Subject: RE: Inglenook P/58/19/PL

For completeness, my report update summarises the main points of the Transport Review as being:

Drawing Title
Refuse Vehicle Access and Egress
and Concurrent Car's Movements

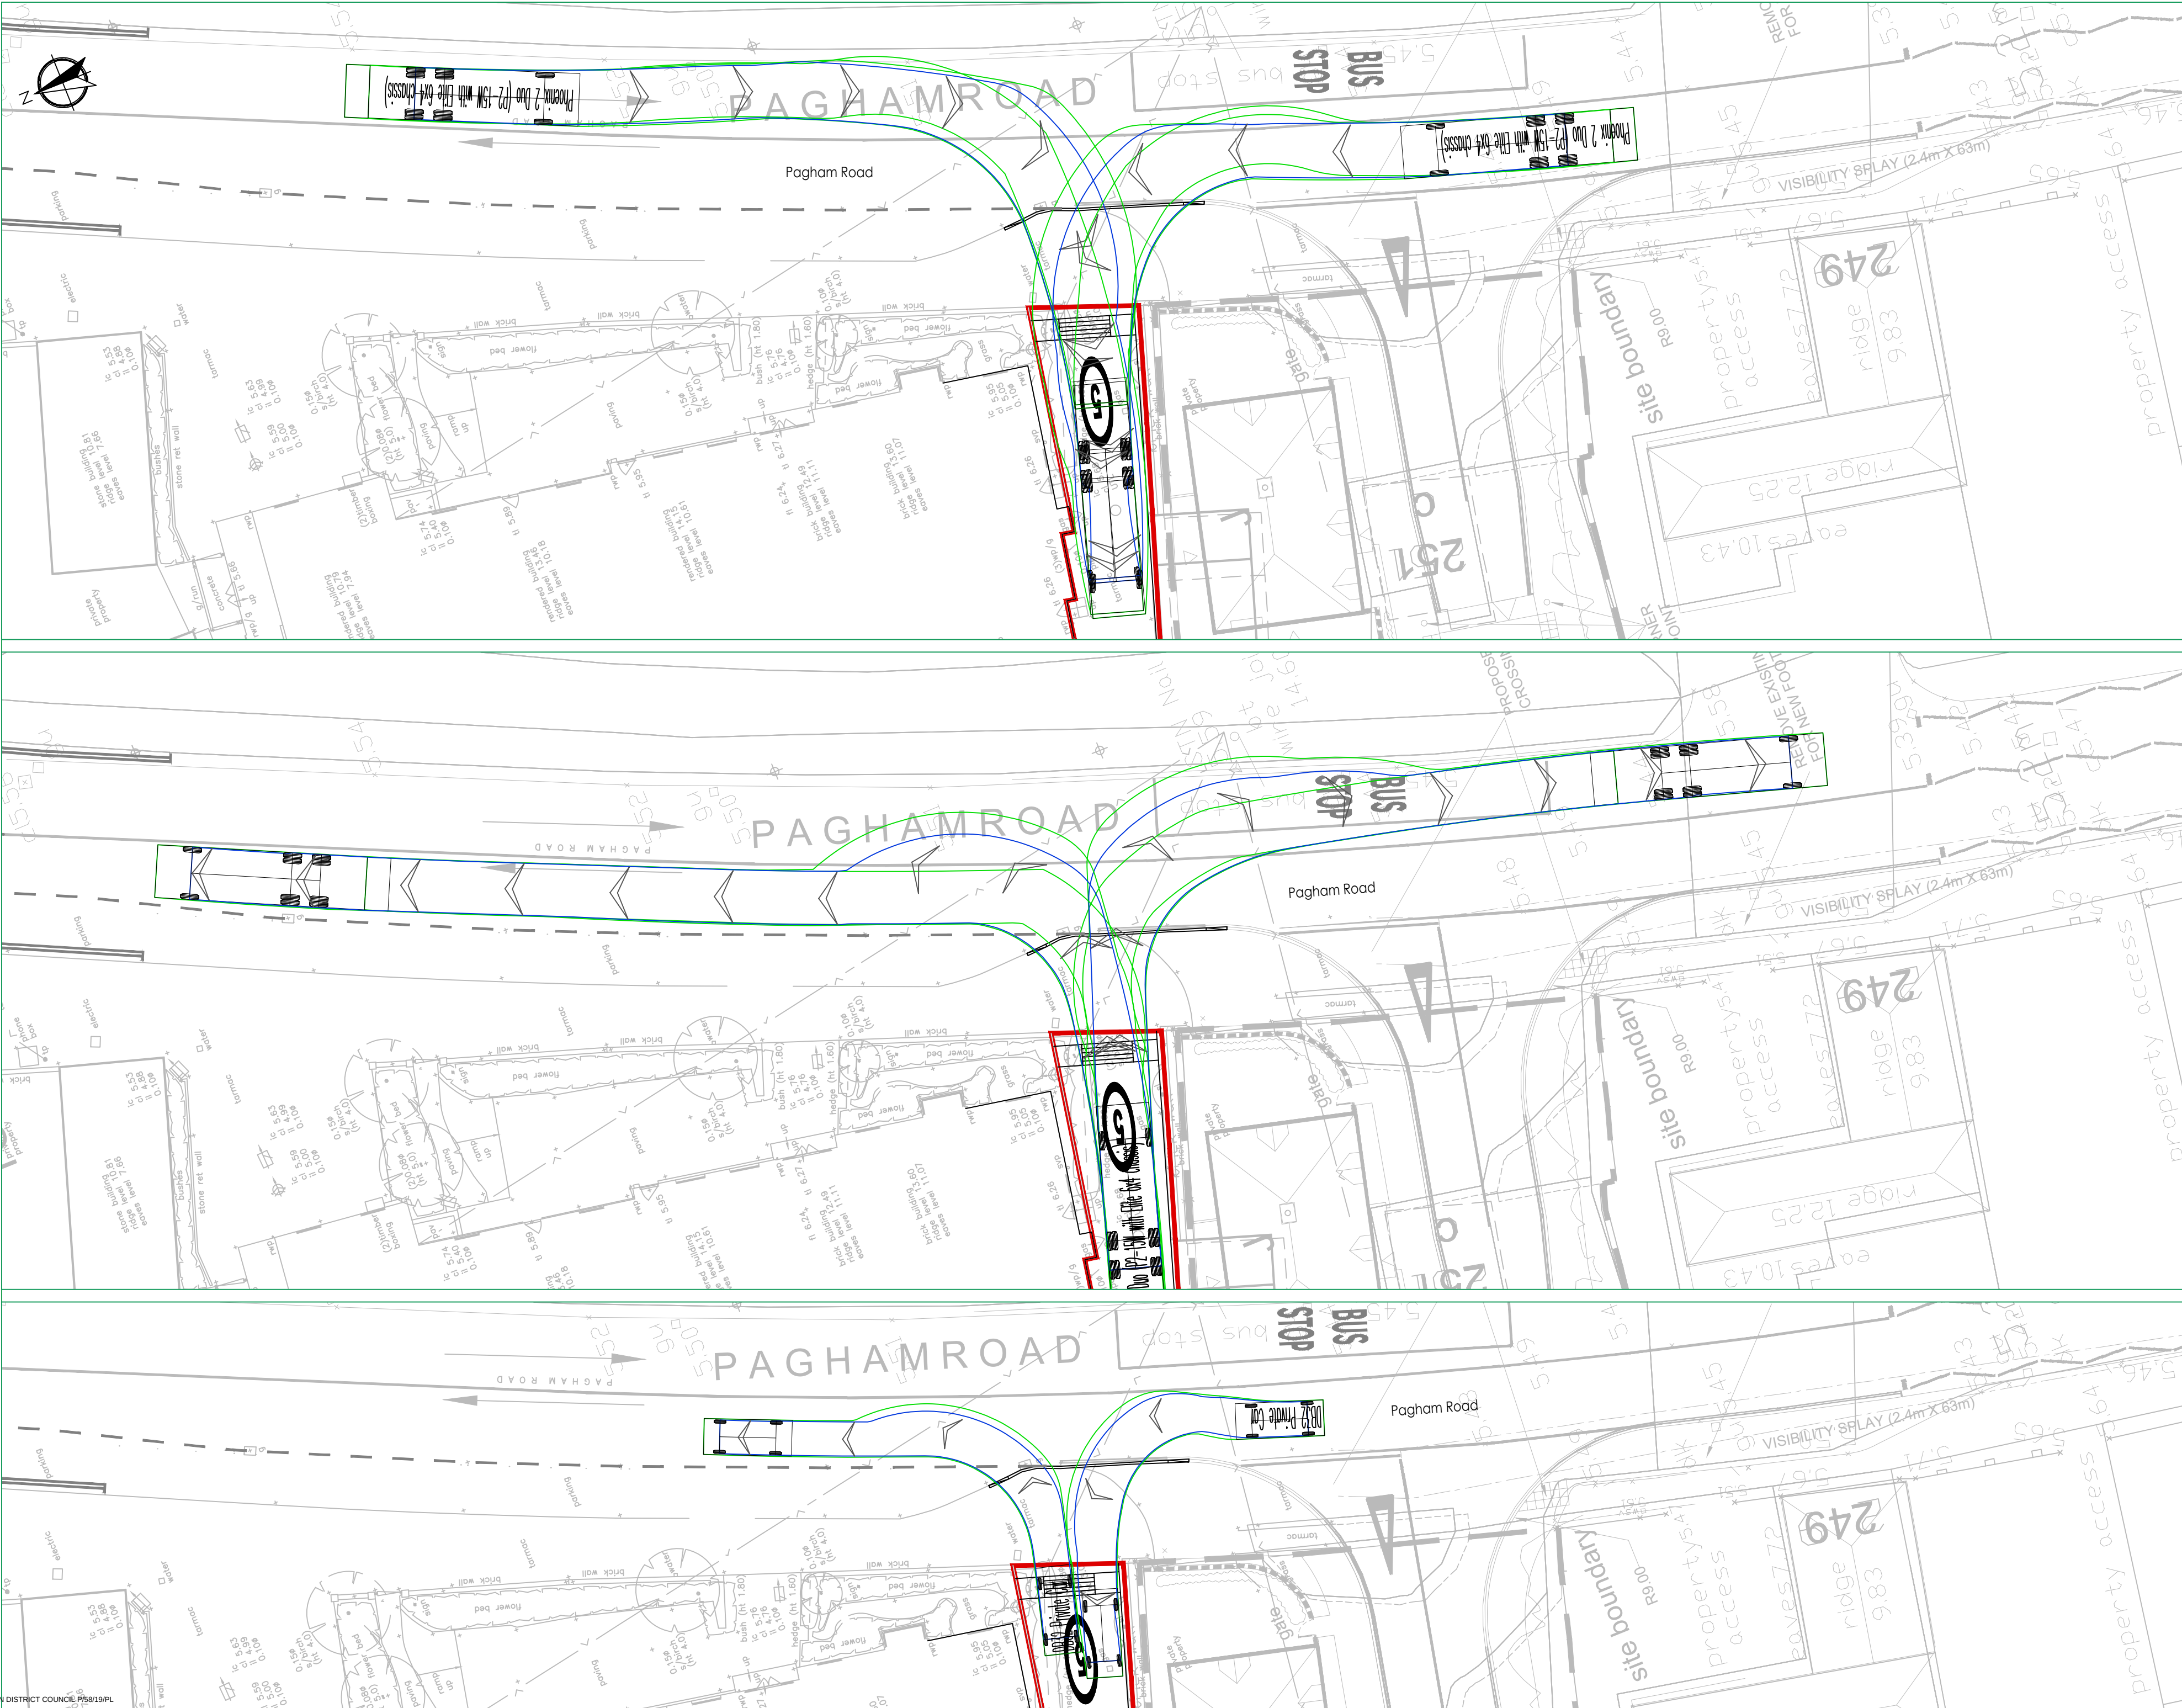
- There does seem to be a trend with collisions at junctions within the area that may present further issues with increased levels of traffic;
- The swept path analysis doesn't take account of any parked vehicles on Pagham Road. There are currently no restrictions and a refuse vehicle would not be able to make a turn with the present arrangements without parking restrictions reducing the existing availability for residents and visitors on-street;

- The swept path analysis of the narrowest part of the access road is very close to lamp columns and steps with no margin of error;
- The additional trips are unlikely to have a detrimental impact to the transport network in the vicinity of the site; and
